Mobile: [REDACTED]  
Email: [REDACTED]  
Our ref: OXF-218785

11<sup>th</sup> January 2024

**Viking CCS Pipeline consultation response relating to the Easington-Immingham Condensate Pipeline, prepared by Strutt & Parker on behalf of Centrica.**

TITLE THE IMMINGHAM FACILITY PLOT PLAN

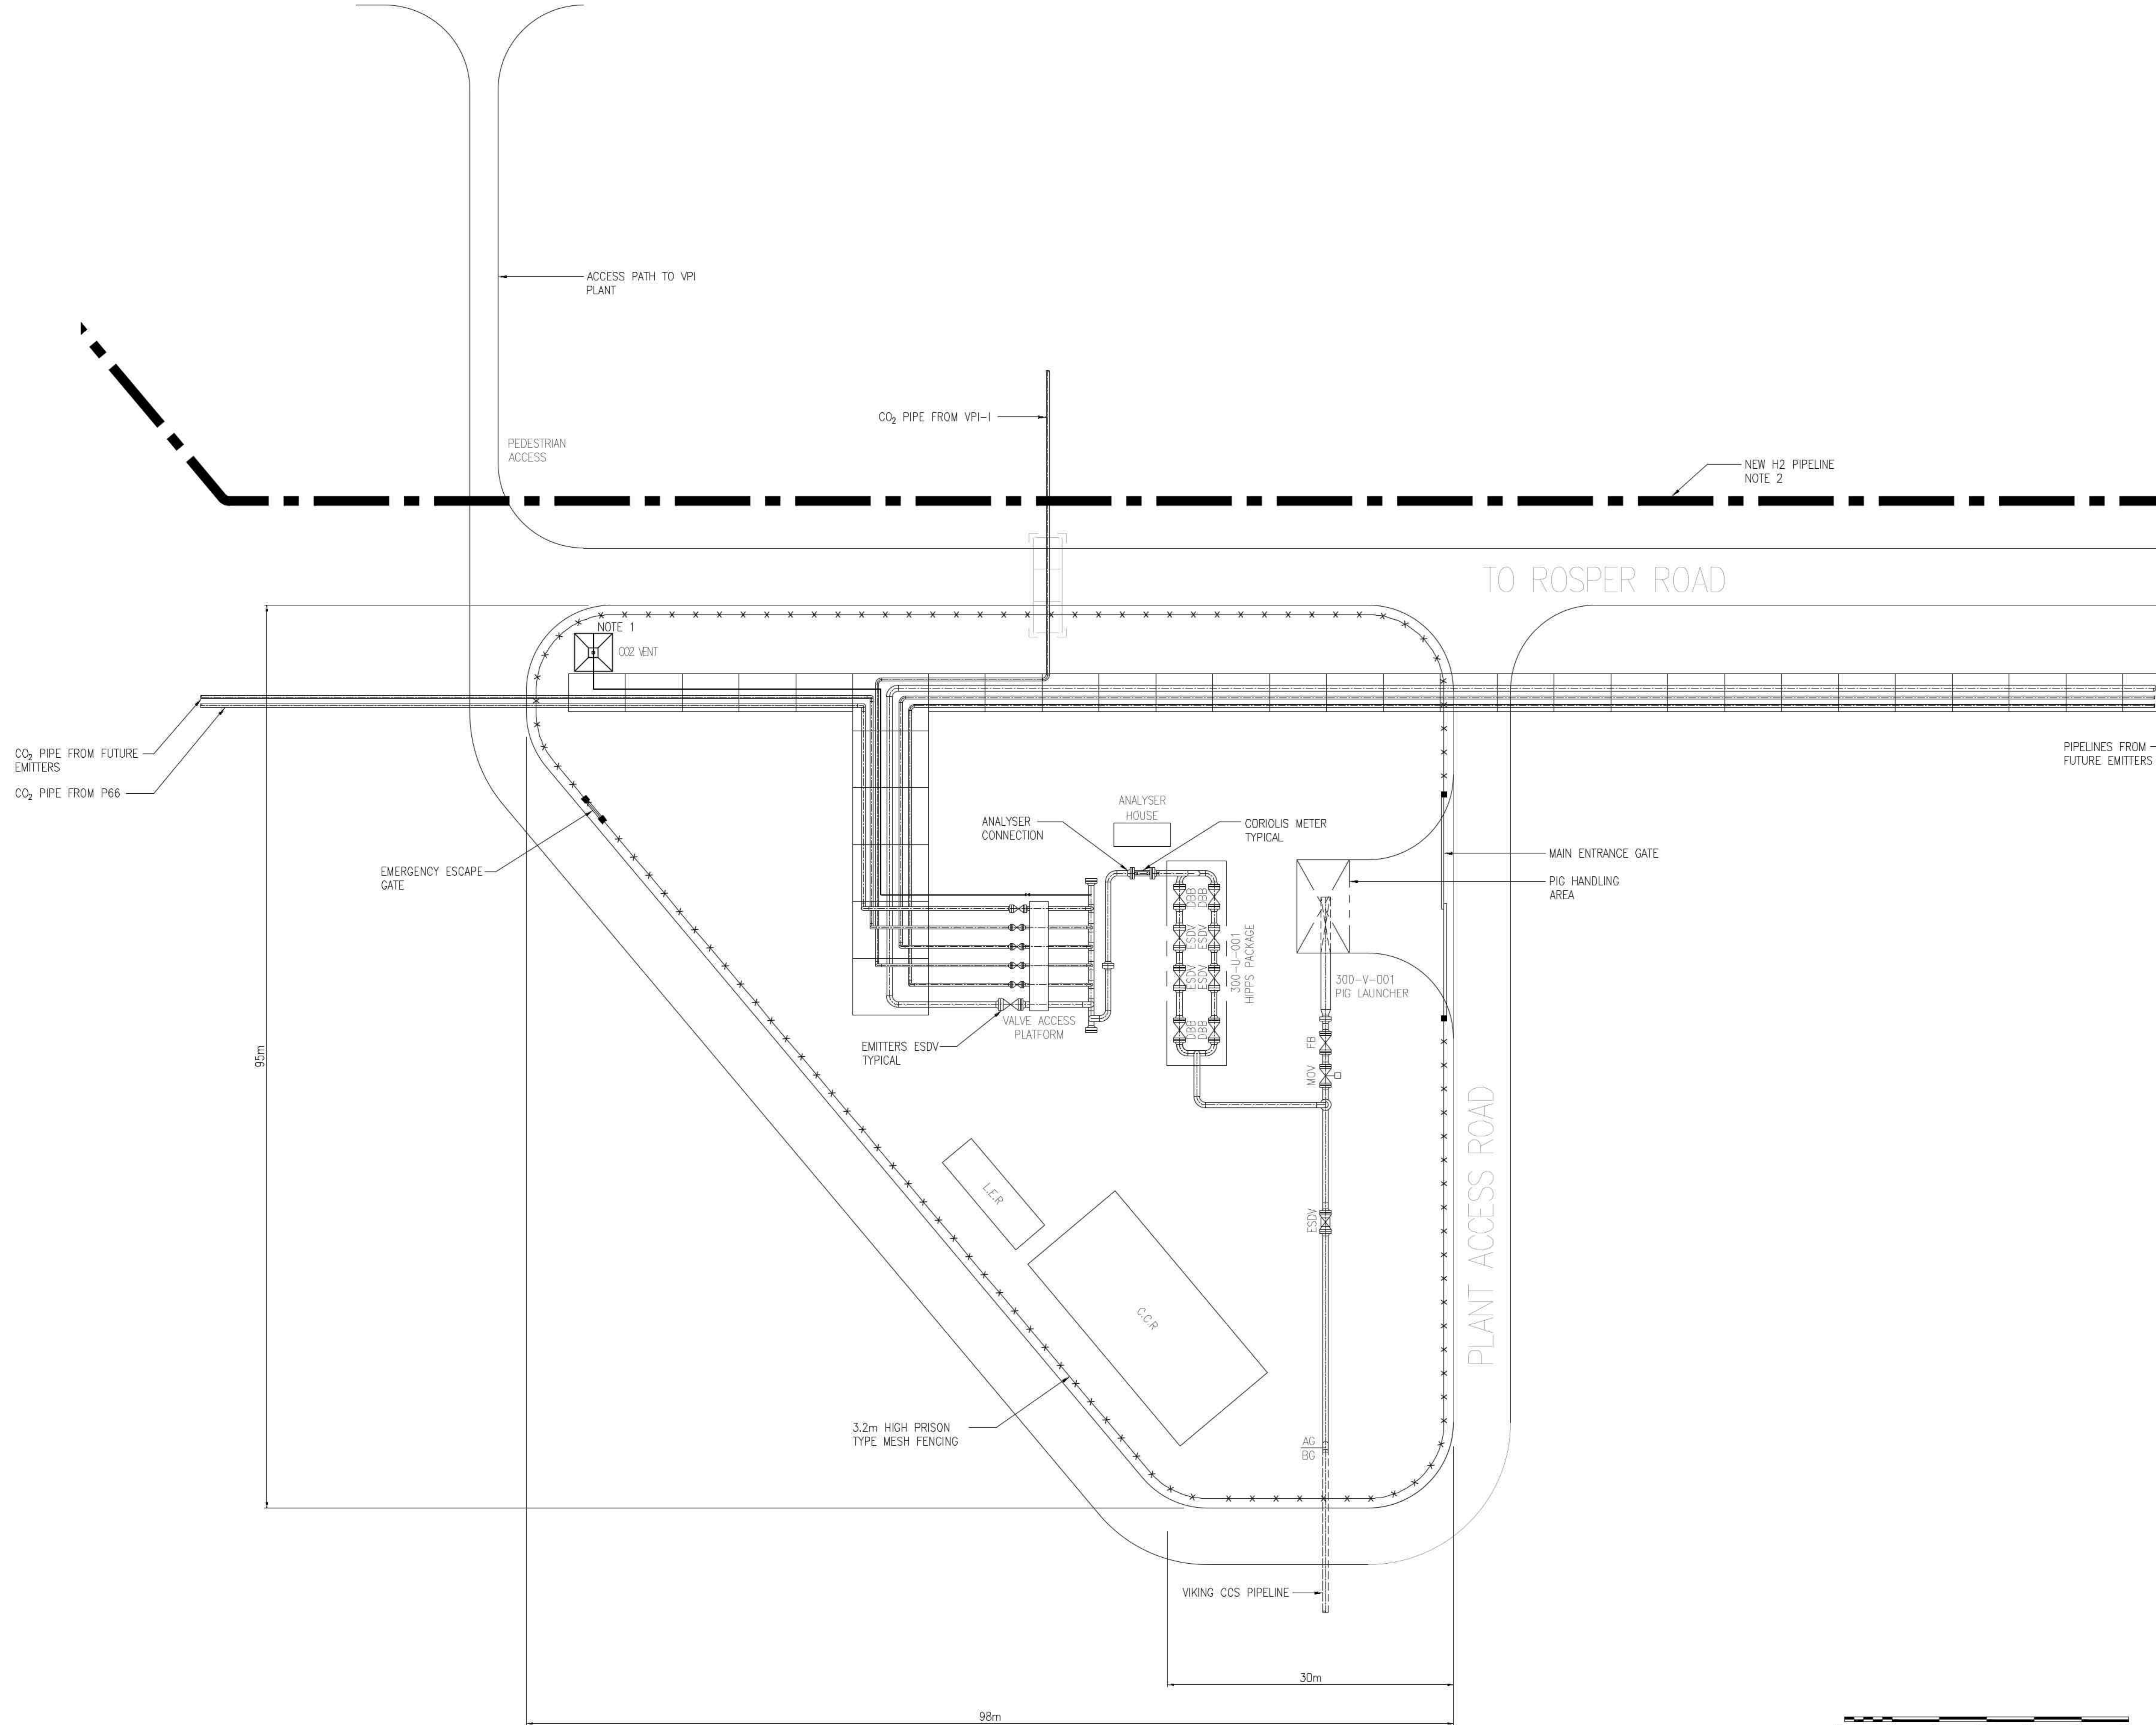
Upon reviewing the Viking CCS Pipeline documents, it has come to our attention that Centrica owns an asset – the CES+ Condensate pipeline which runs between Easington and Immingham, and is located in the immediate vicinity and apparently within the red line boundary of the proposed Viking CCS Pipeline; specifically nearby the proposed ‘Immingham Facility’ in Section 1, as referred to in the application documents. The CES+ Condensate pipeline is located under or immediately adjacent to Rosper Road, at the western boundary of the proposed Immingham Facility site.

In the first instance we are concerned to (a) ensure that Harbour Energy are aware of the existence of the condensate pipeline, (b) establish whether there is any potential conflict between the planned Viking CCS Pipeline and the existing CES+ Condensate pipeline, and (c) establish the necessary processes to ensure that the proposed Viking CCS Pipeline and associated works are able to be implemented safely and without undue disruption to the Condensate pipeline.

Prior to any works being undertaken, and to identify any underground services, the planning details for the Viking CCS pipeline route should be submitted through [REDACTED], this will identify the CES+ pipeline and any other assets in the vicinity.

Once the scope of works has been assessed, it will be determined if the CES+ pipeline route needs to be positively identified at site, or have close supervision by a Penspen Pipelines Superintendent to ensure works are carried out in accordance with HSG47 – Avoiding danger from underground services.
